# Consultee Comments for Planning Application 21/02118/FUL

Application Number: 21/02118/FUL

Address: Land adjacent to 145 Connaught Avenue Frinton On Sea Essex CO13 9AH

On Behalf Of: Tree & Landscape Officer

• BLOCK PLAN 1:200 •

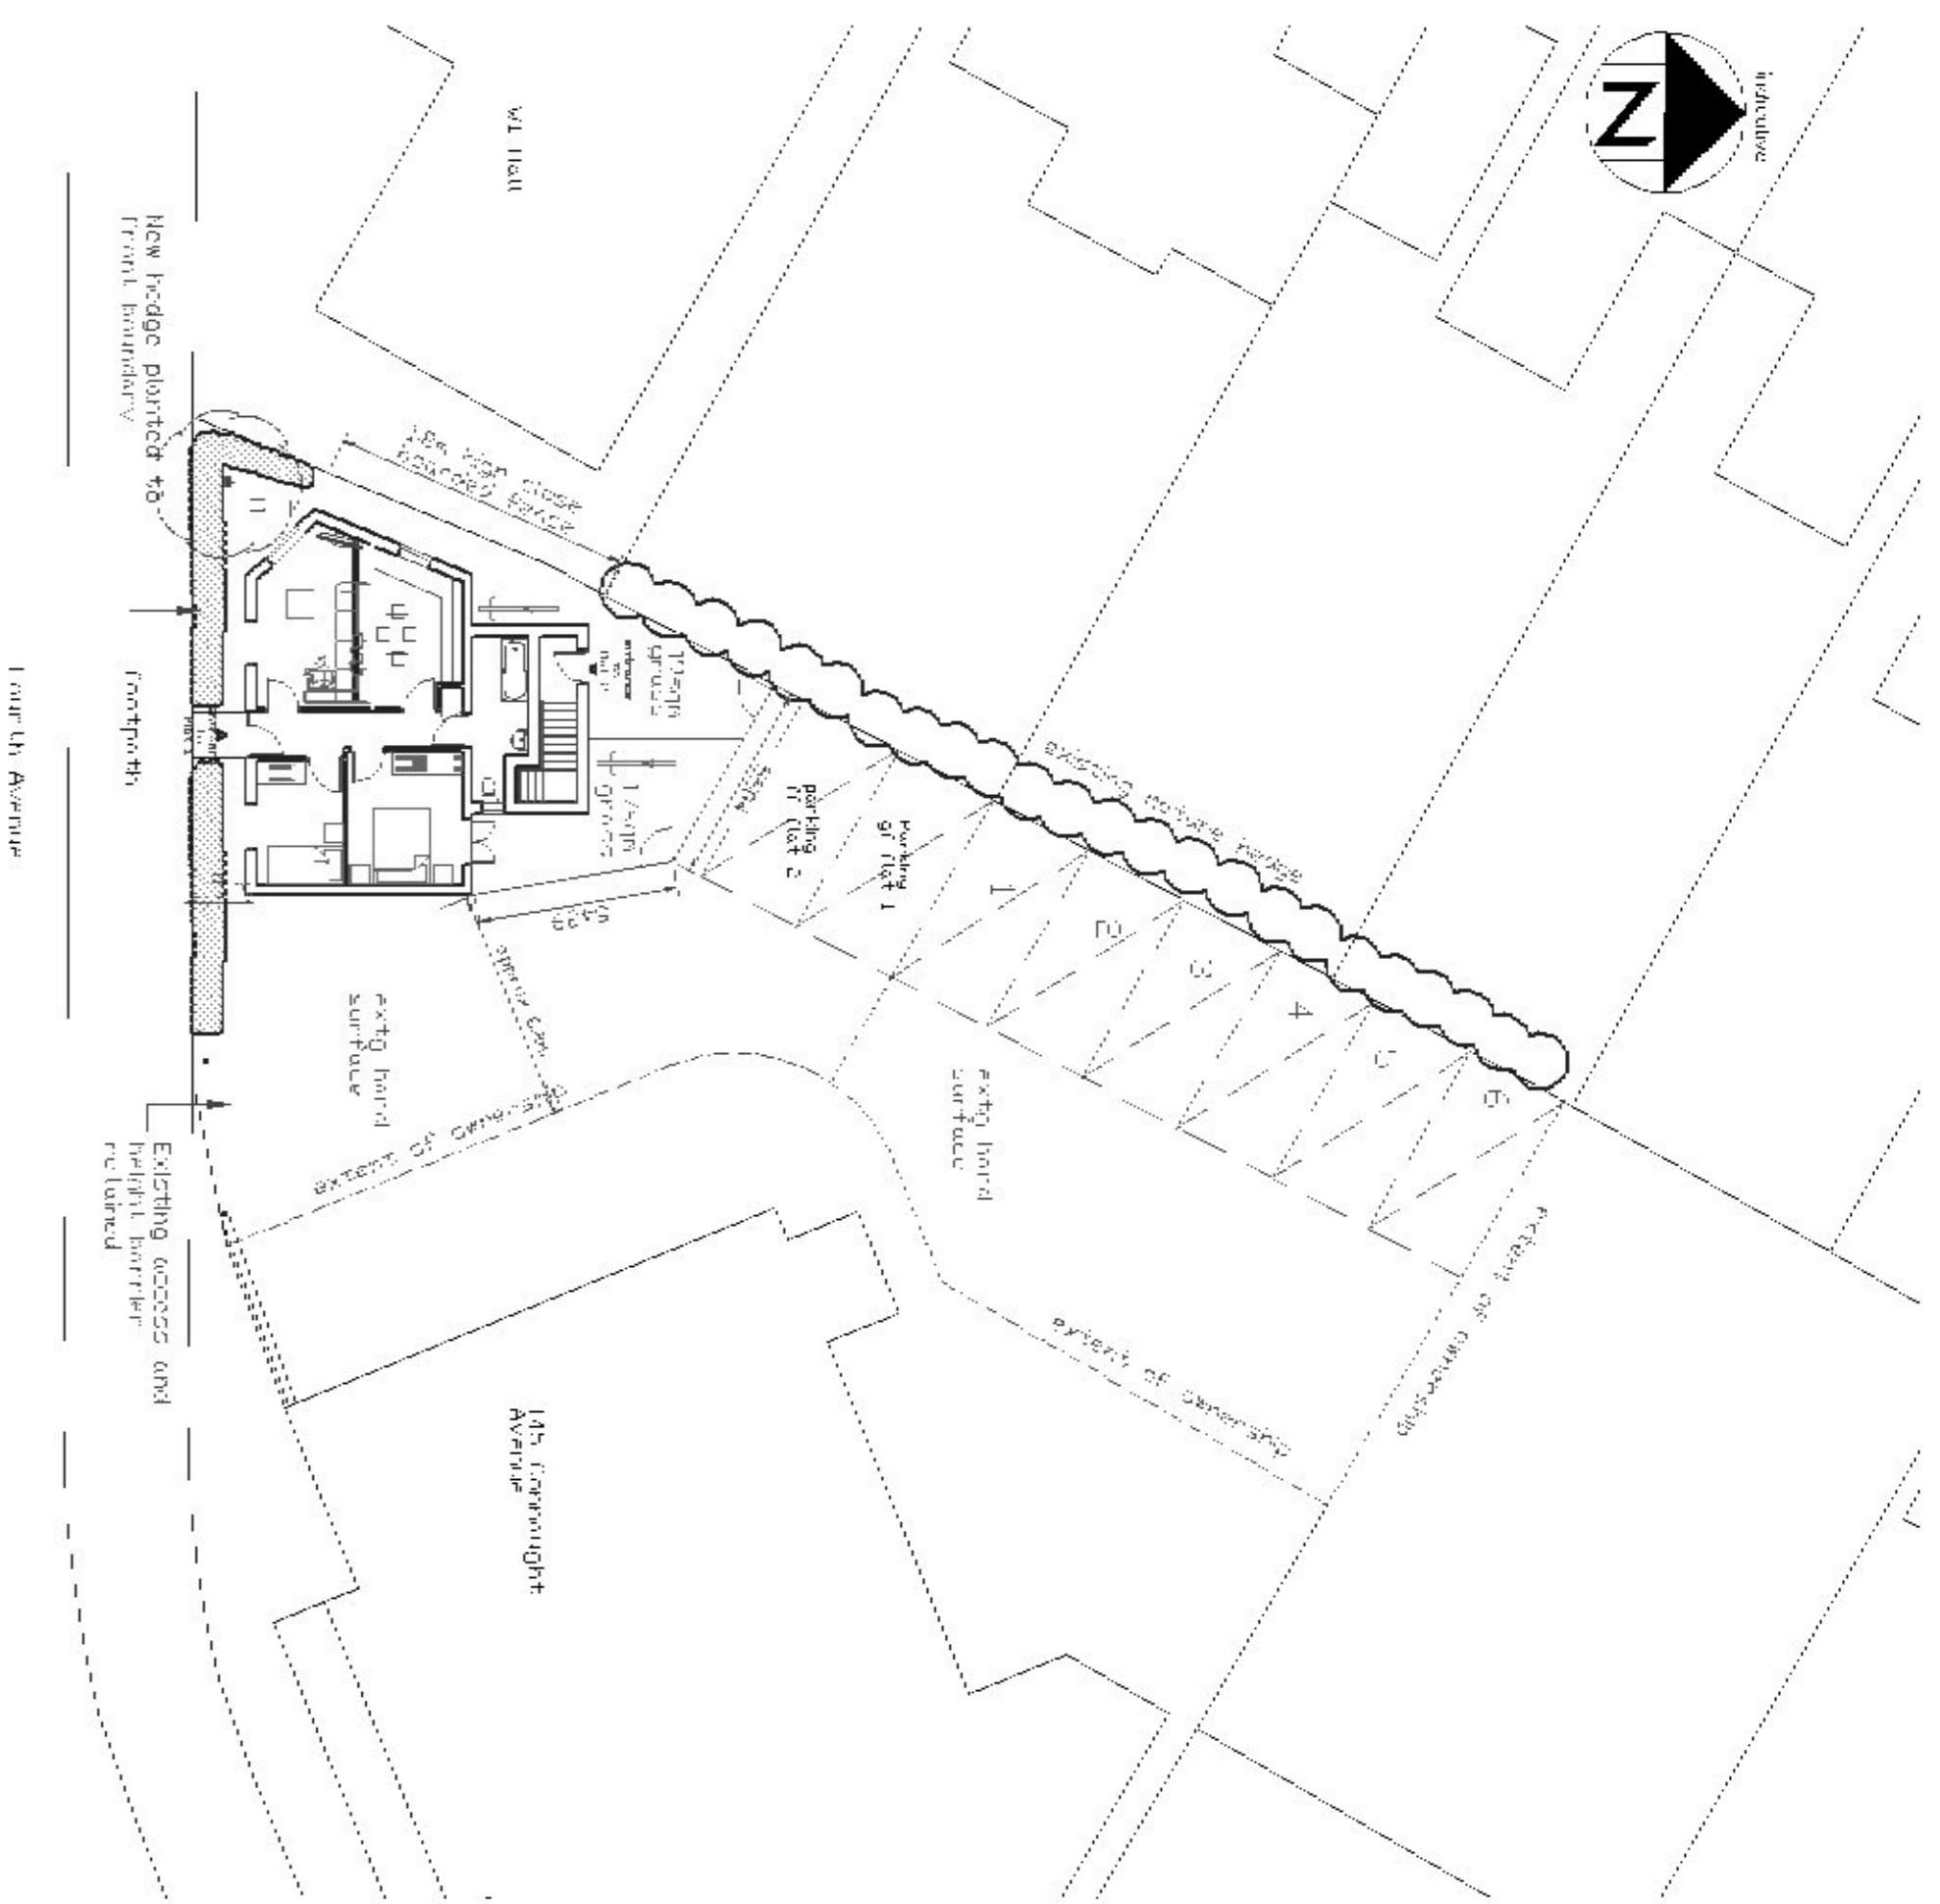
In terms of soft landscaping the site layout plan shows that a new hedge will be planted to replace the Euonymus hedge and that a single new tree will be planted in the south western corner of the application site

In this regard the soft landscaping proposals are acceptable.
